Rezoning Transportation Analysis

Petition Number: 2020-055

General Location Identifier: Tax ID 04739109

Date	Description
05-18-20	First Review
06-28-20	Second Review
08-25-20	Third Review

SHEET NUMBER **RZ-1**

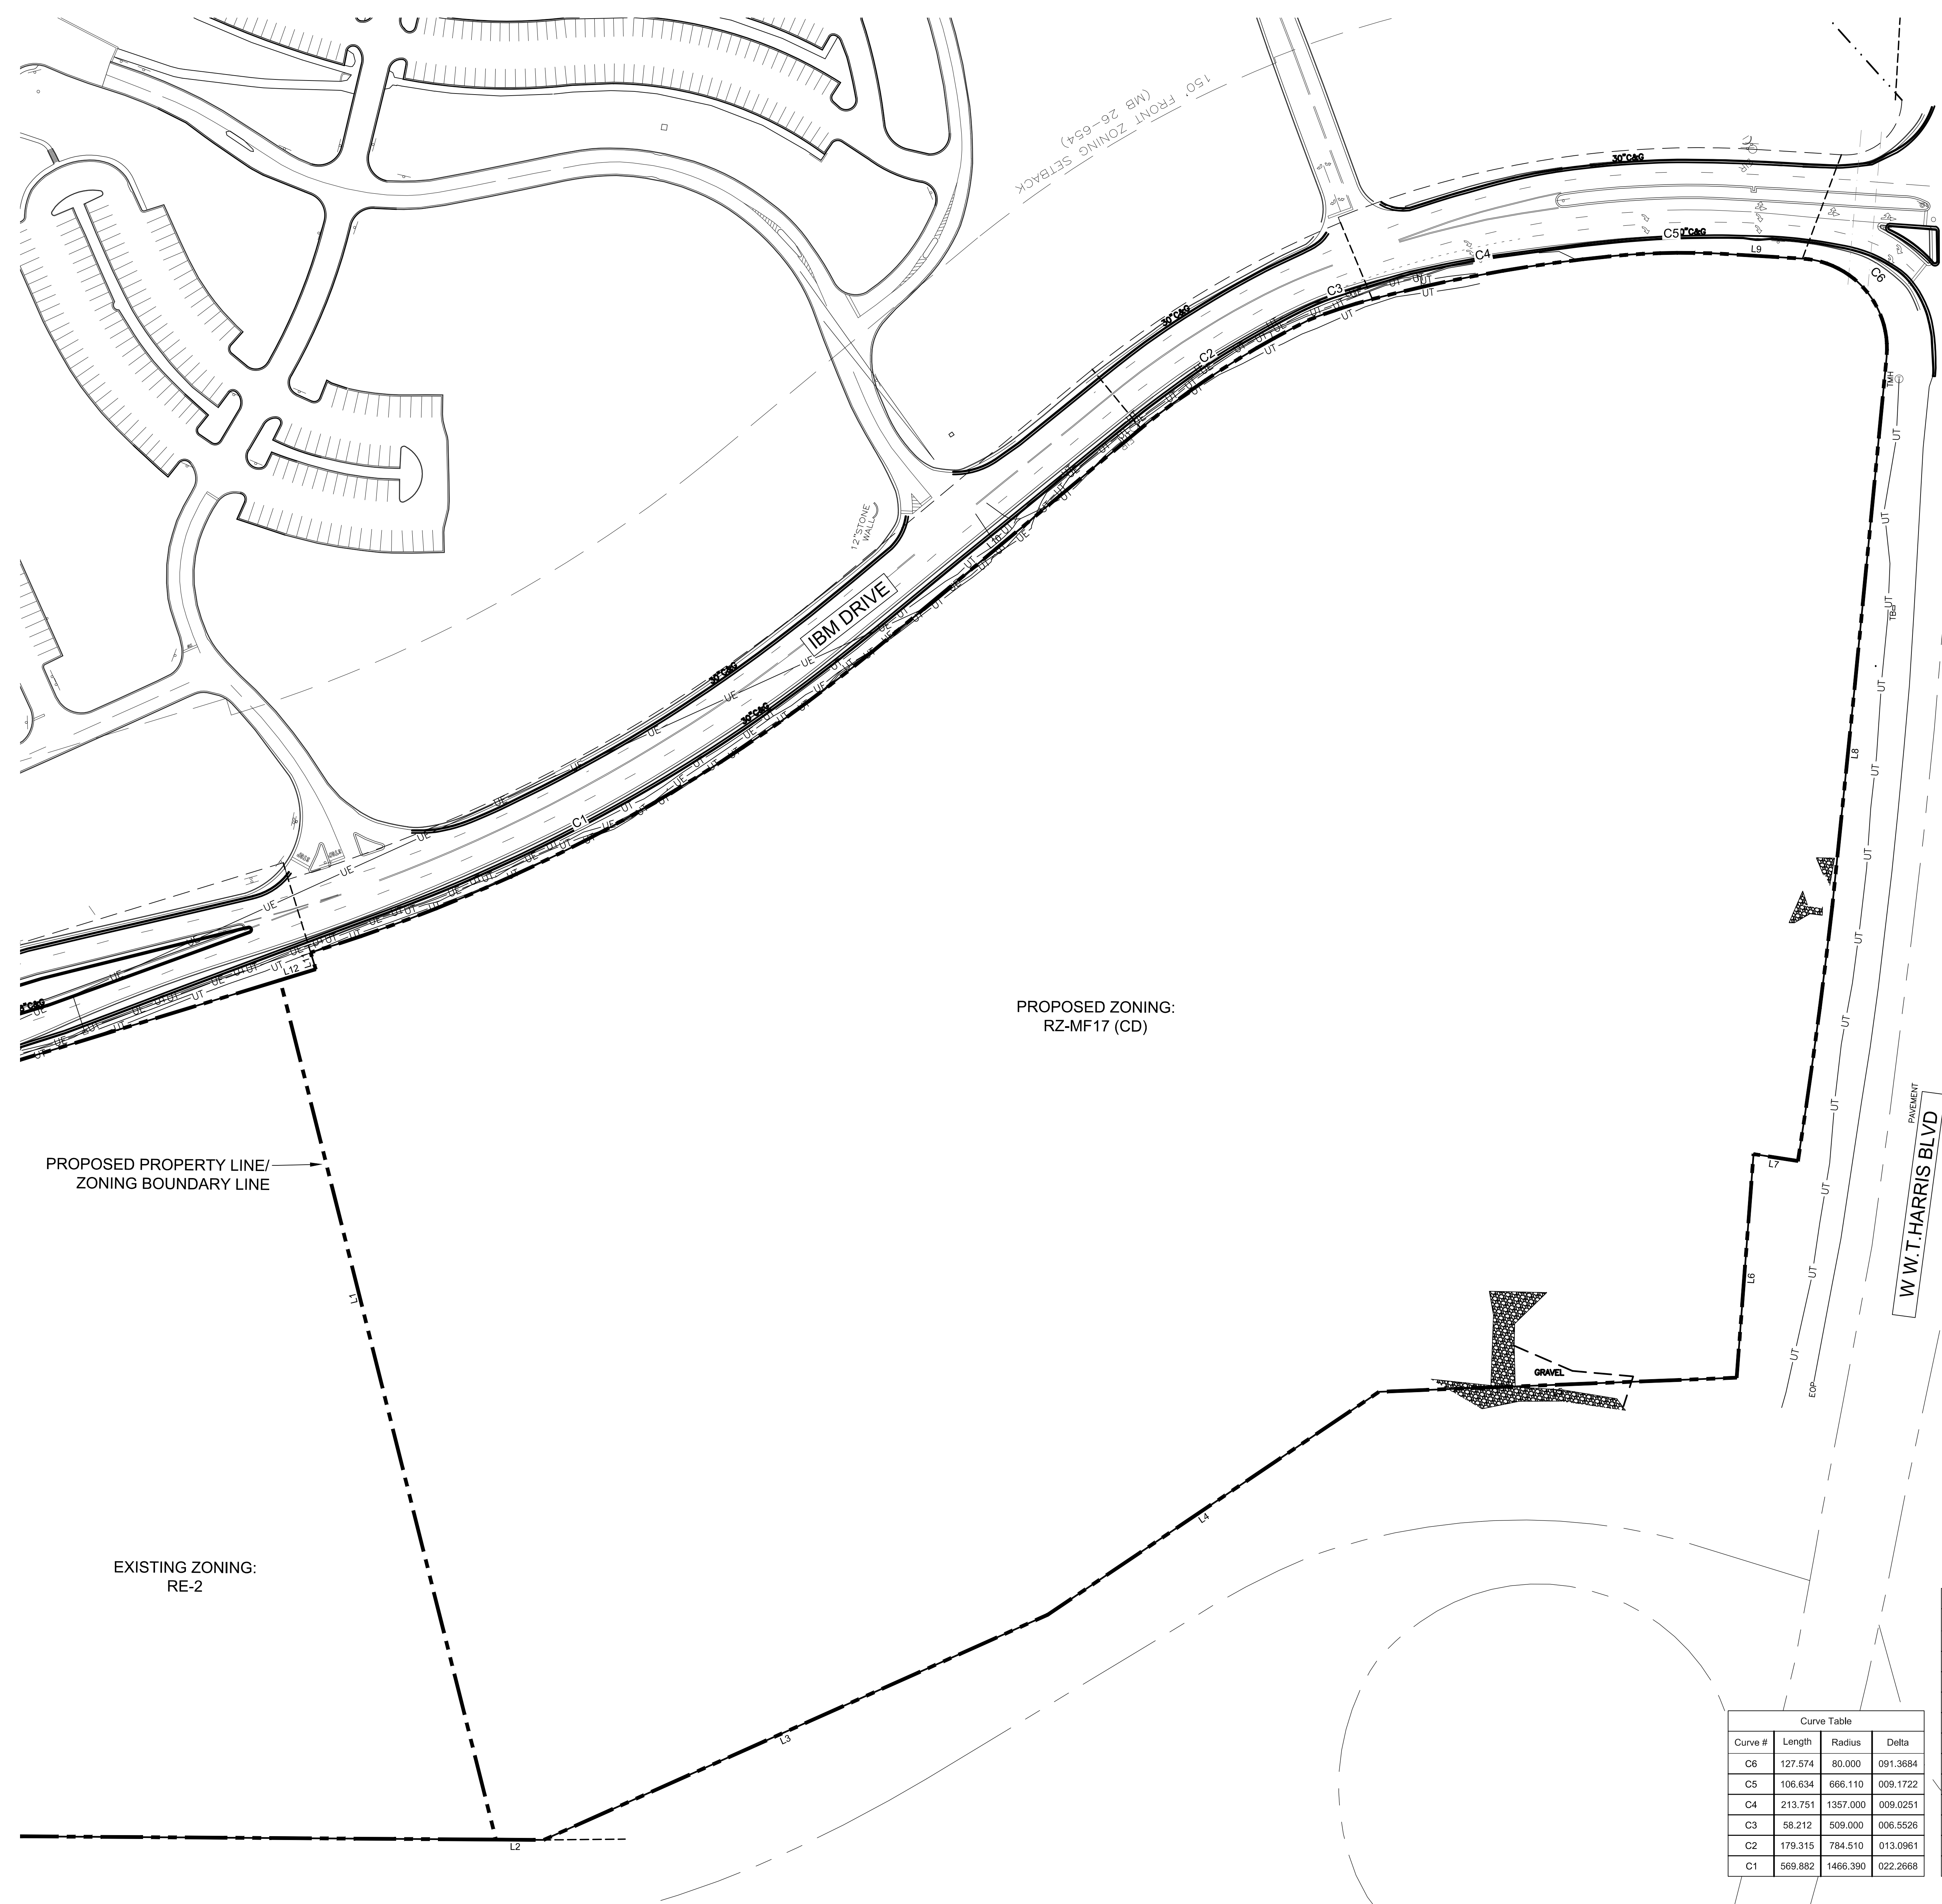
Outstanding (site plan dated 8-17-20) The site plan should show the curb and gutter labeled and dimensioned from the centerline for each road.

3. **Outstanding (site plan dated 8-17-20)** The petitioner should revise the site plan and conditional note(s) to commit to construct bicycle facilities by installing a 12' multi-use path along the perimeter of the parcel to meet the City Charlotte BIKE Policy, with two accessible ramps.

a. **New comment (site plan dated 8-17-20)** The petitioner should also commit to including accessible ramps, per PROWAG requirements, to the channelized median at IBM Drive & W.T. Harris Boulevard.

- The petitioner should revise the site plan to add a note specifying all transportation improvements will be approved and constructed before the site's first building certificate of occupancy is issued. The petitioner may phase transportation improvements if said improvements and phasing are explicitly described in site plan notes.
